Application Ref: 3/2025/0411 - Dene Cottage 9 The Dene Hurst Green BB7 9QF

Proposal: Listed Building Consent for internal and external works. External works to include: replacement of windows and lintels, enlargement of window openings, infill doorways and windows, demolition of existing lean-to and erection of oak framed porch, replacement of roof tiles with slates, replacement of cills and mullions, replacement of guttering and downpipes, removal of render and repoint with lime. Internal works to include: replacement of existing staircase, removal of partitions, excavation of internal floor to increase head height and replacement of internal floor with limecrete.

HISTORIC
BUILDINGS
& PLACES

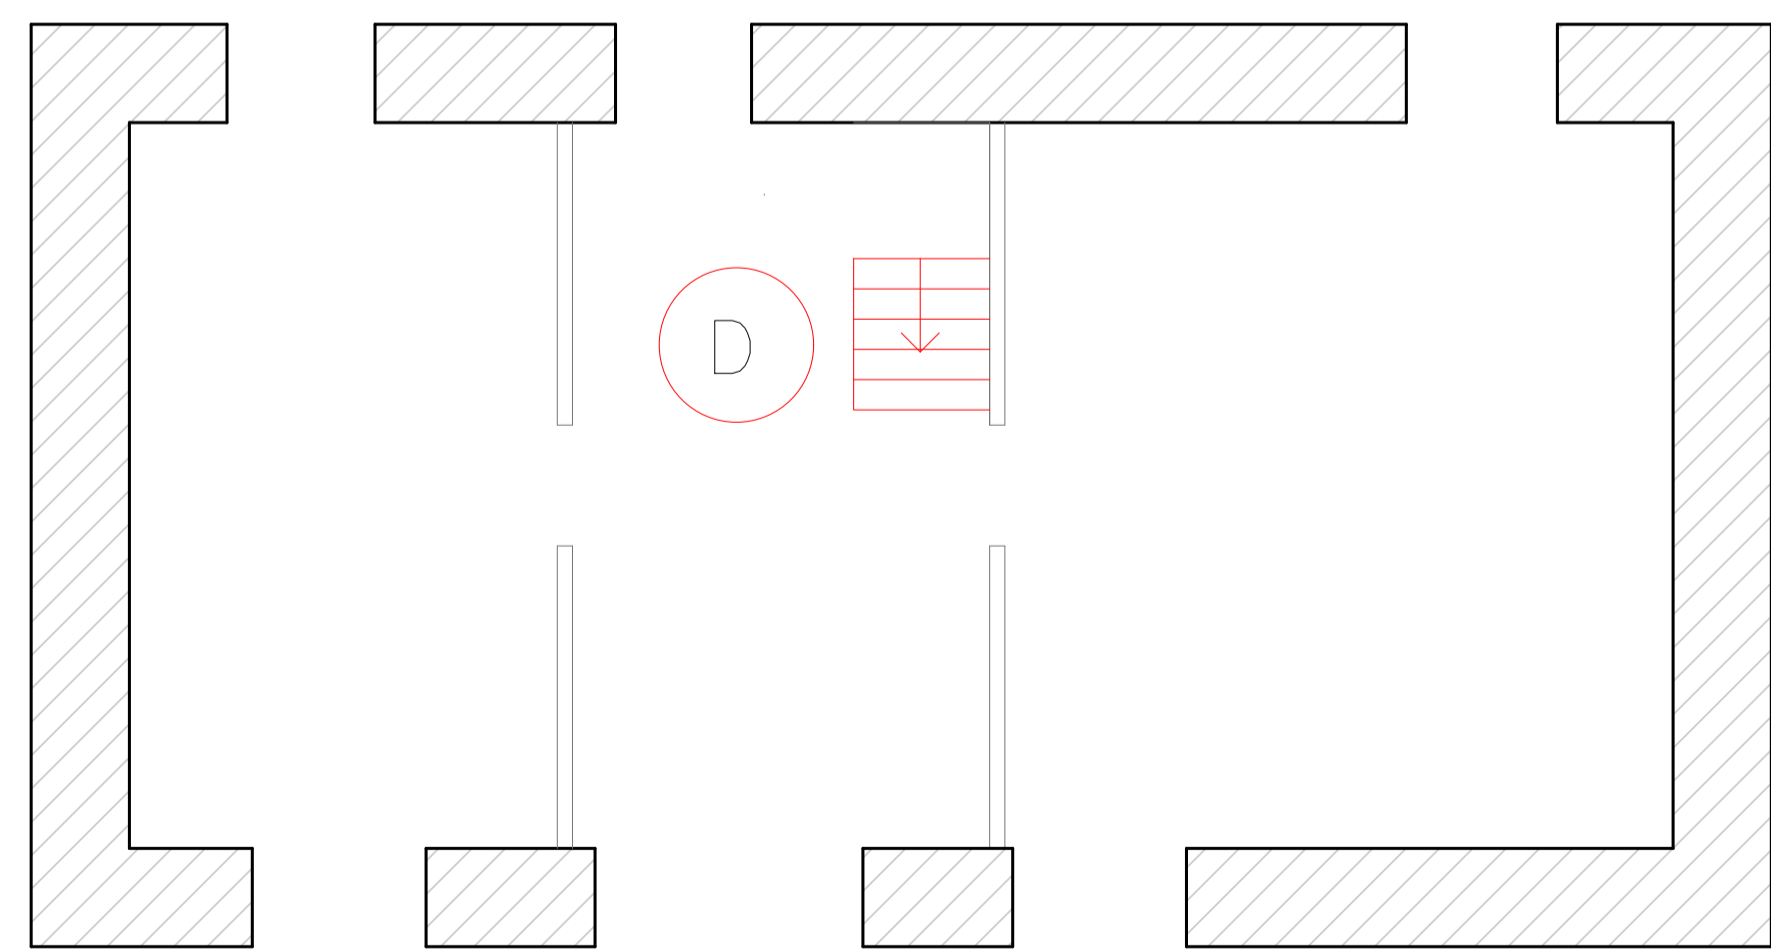
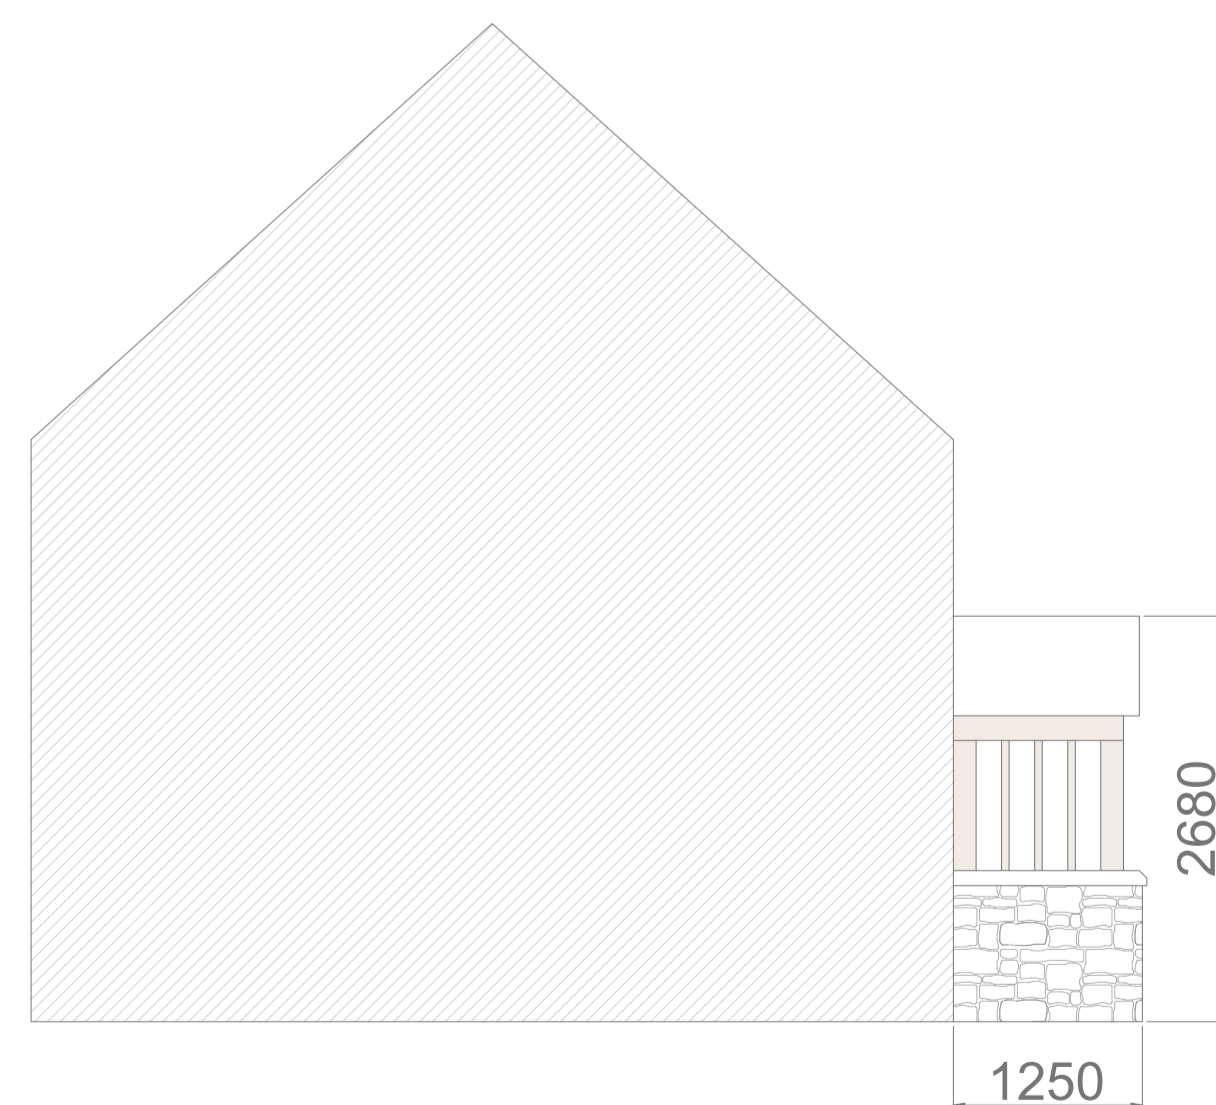
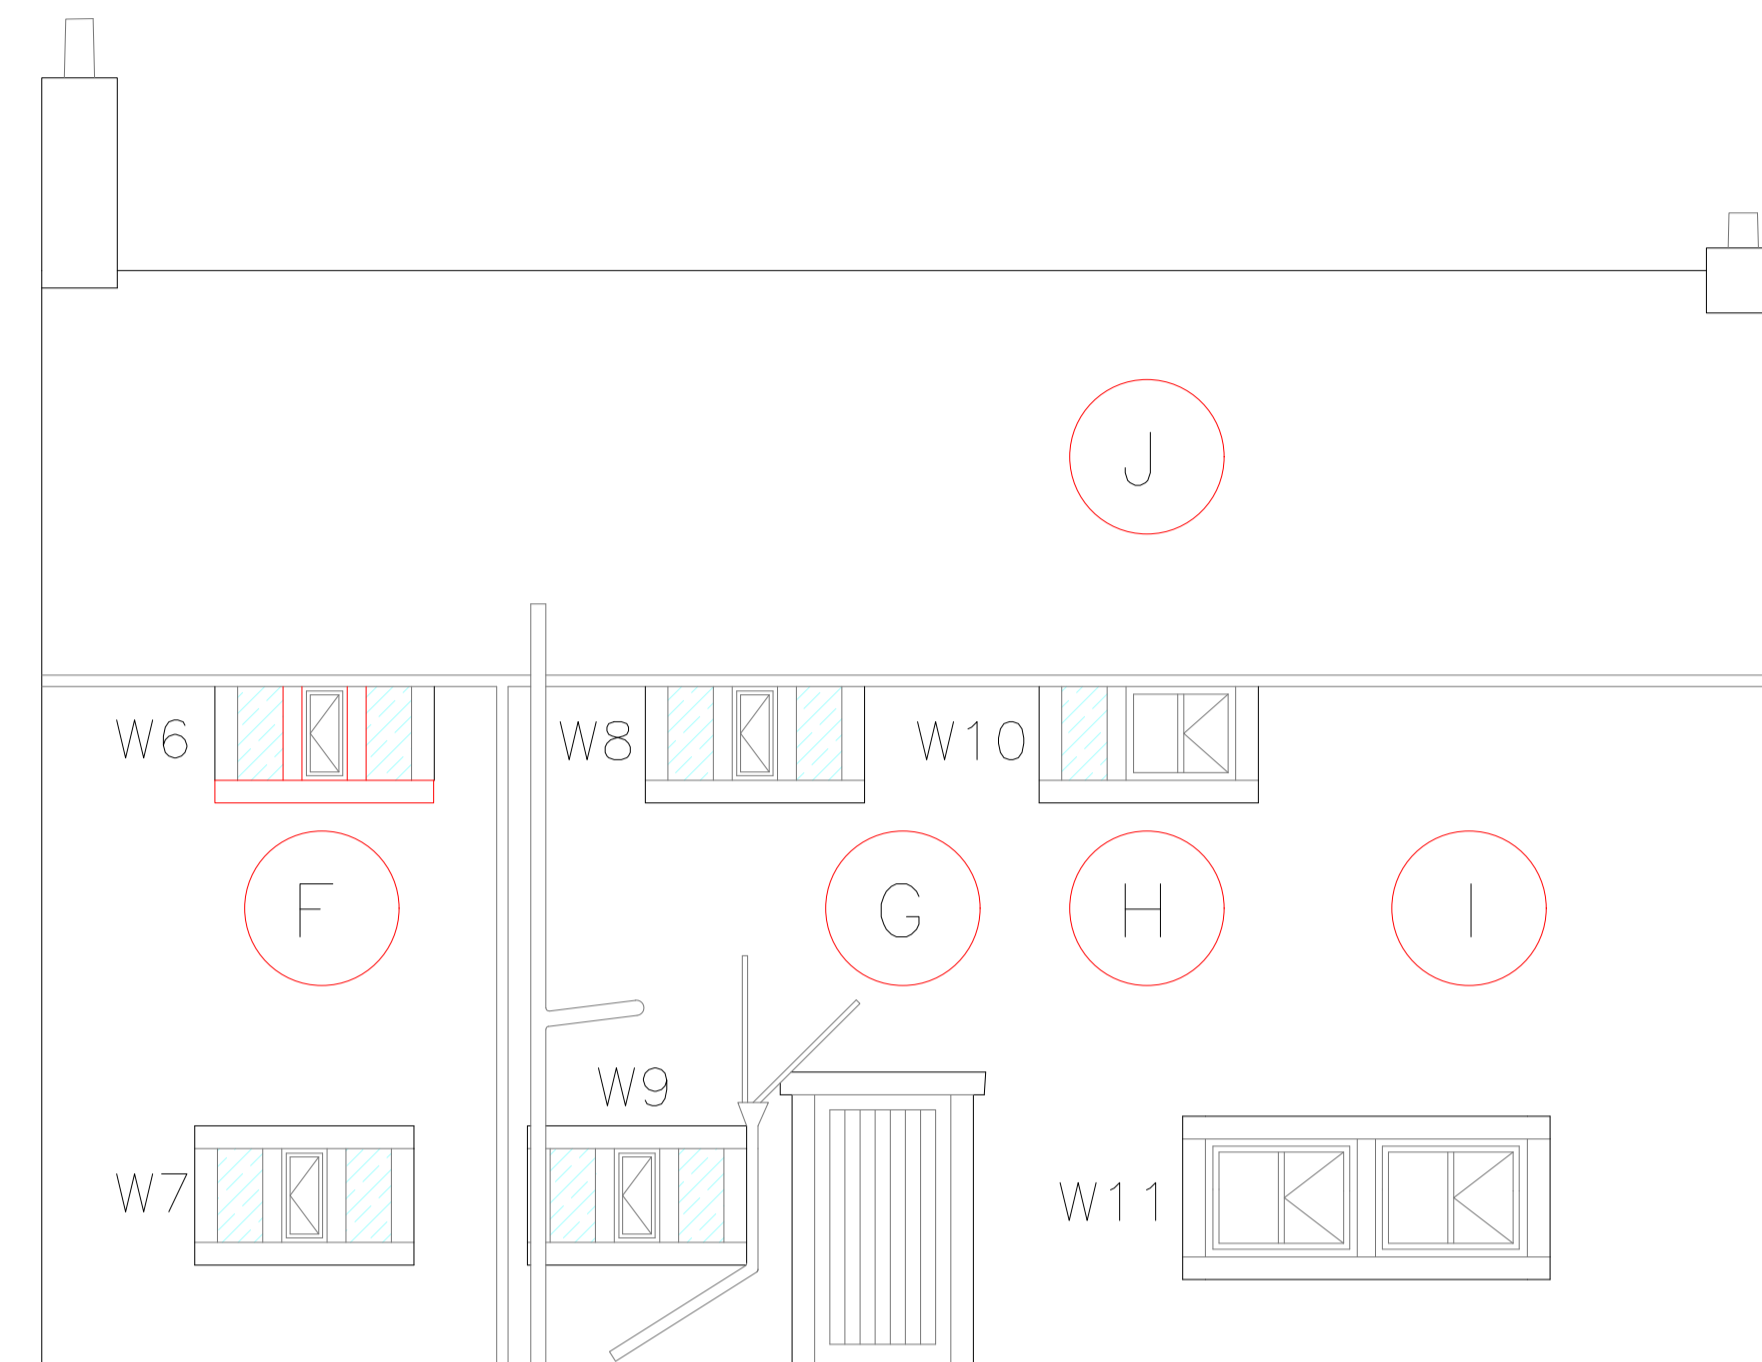
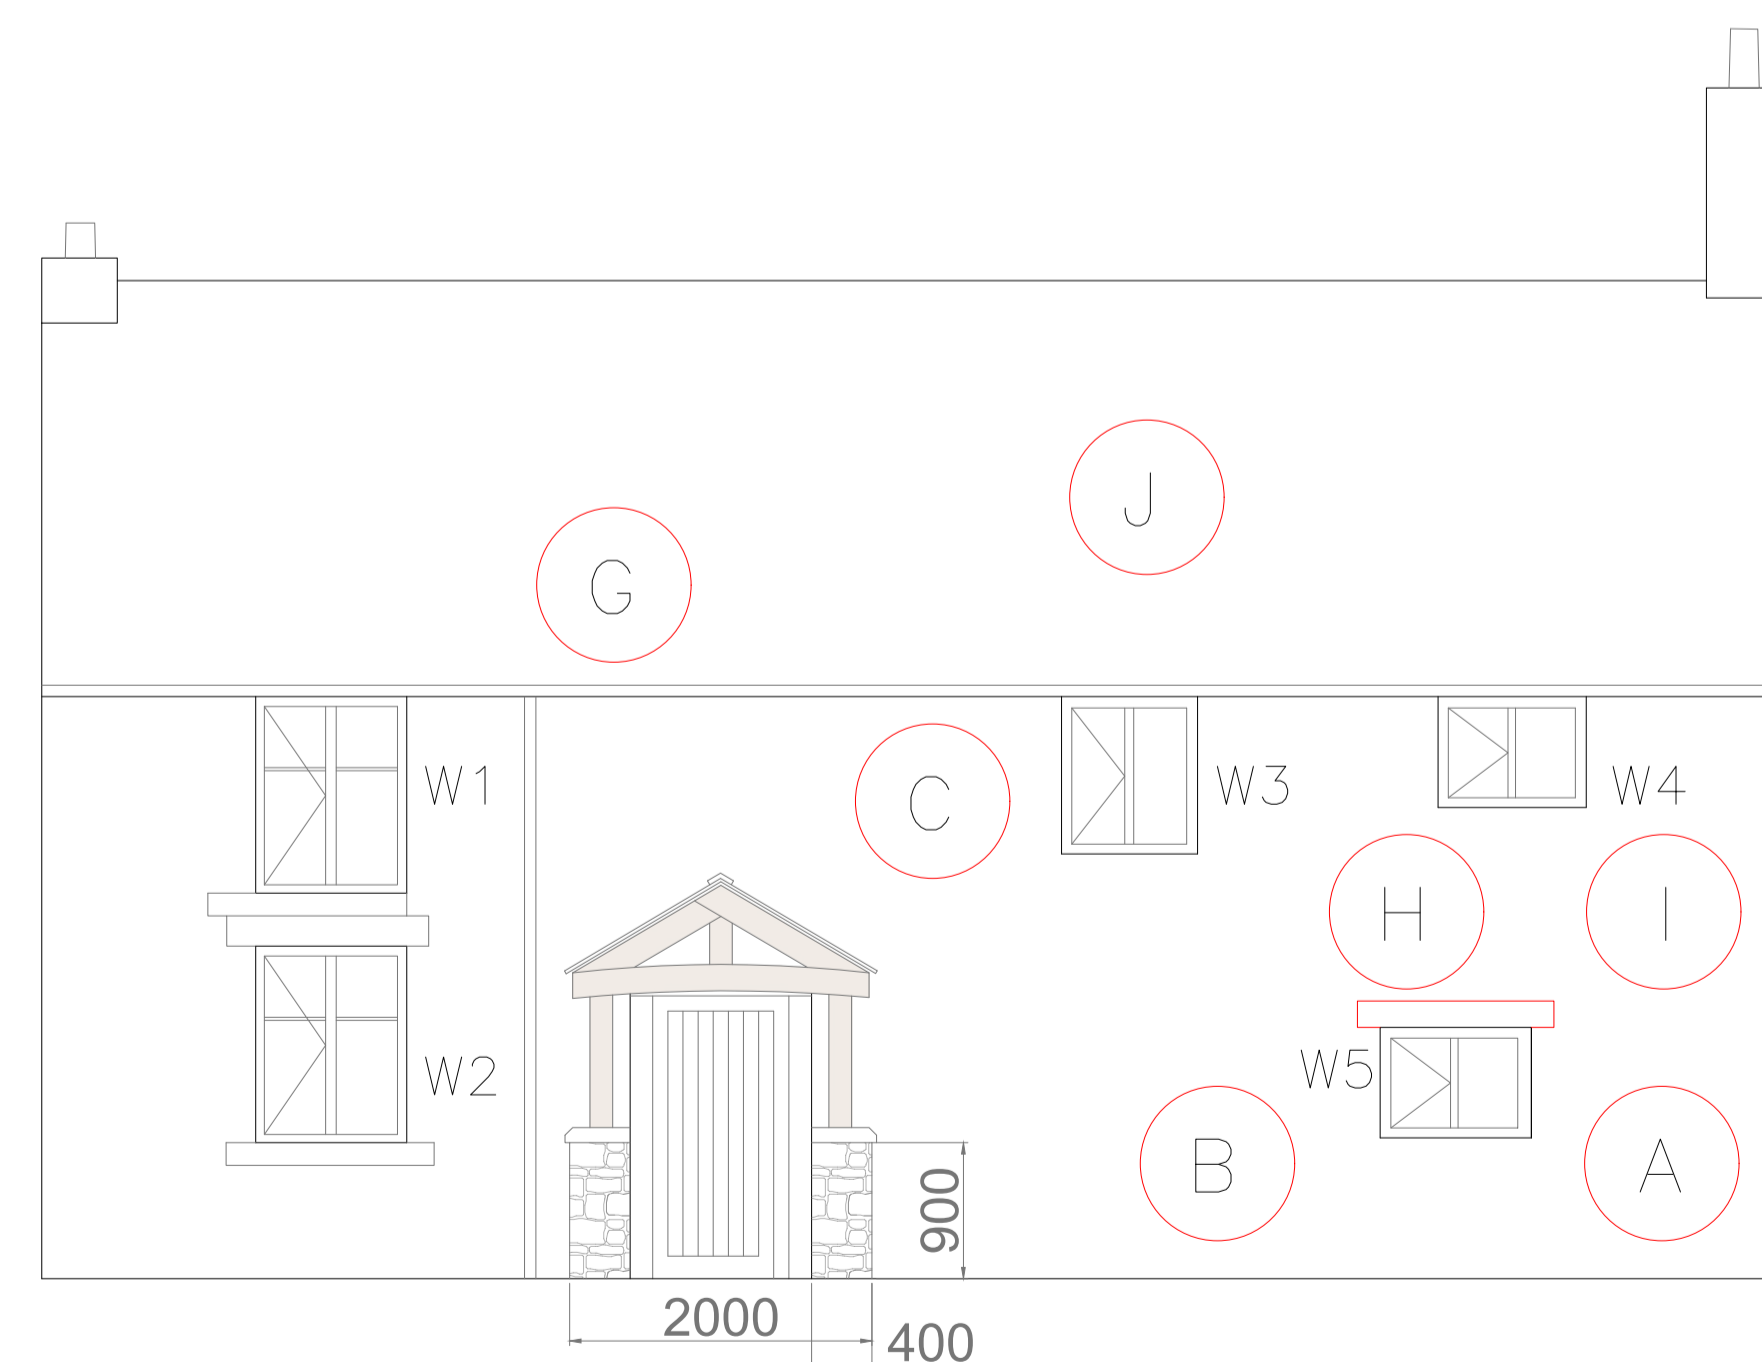
- The revised plans submitted for the 'proposed elevations' are welcome, in that the fenestration pattern has been revised to include more appropriate replacement casement windows, rather than top opening windows.
